CITY OF ALBUQUERQUE

August 3, 2021

Re: OSH MONTANO ROAD
333 Montano Road NW
Traffic Circulation Layout
Engineer's/Architect's Stamp 7-30-21 (F14-D023)

Sheet Title
TRAFFIC CIRCULATION LAYOUT
Scale: As indicated
Drawn: JED
Project No.: 064559810
Sheet No.: **C201**

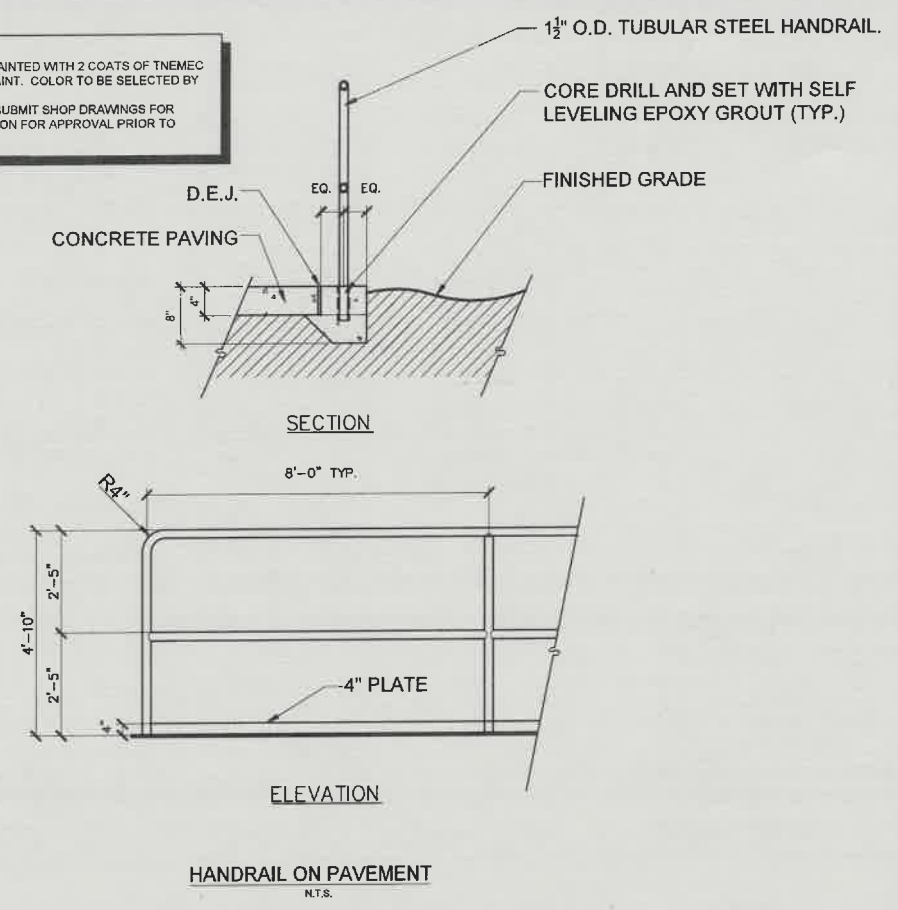
2. **Sheet C201 (Montano Road shaded area):**

- Shown is a shaded area (5ft x 13.4 ft)** on Montano Road labeled as asphalt pavement work should read **Asphalt work shall be accomplished by mini work order by Water Authority tapping permit.**

C203

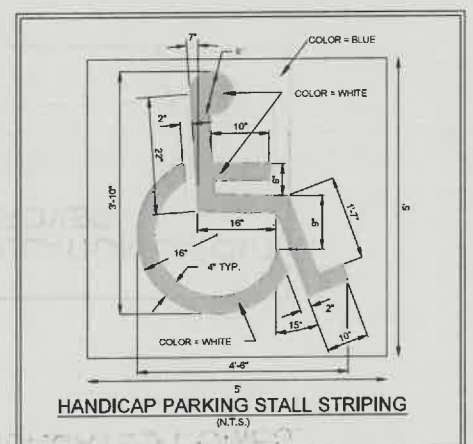
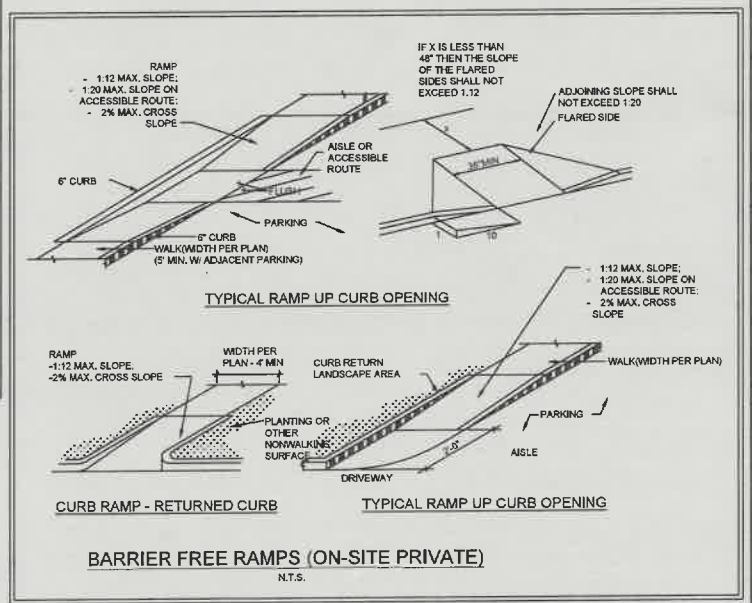
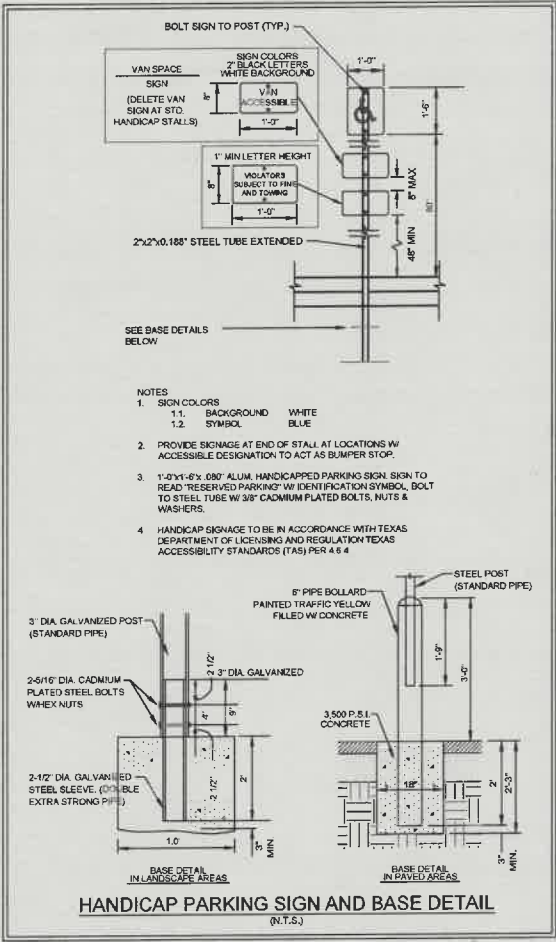
4. **Proposed Handrail (sheet C203-Handrail on Pavment detail):** Show the 4 inch plate at bottom of handrailing.
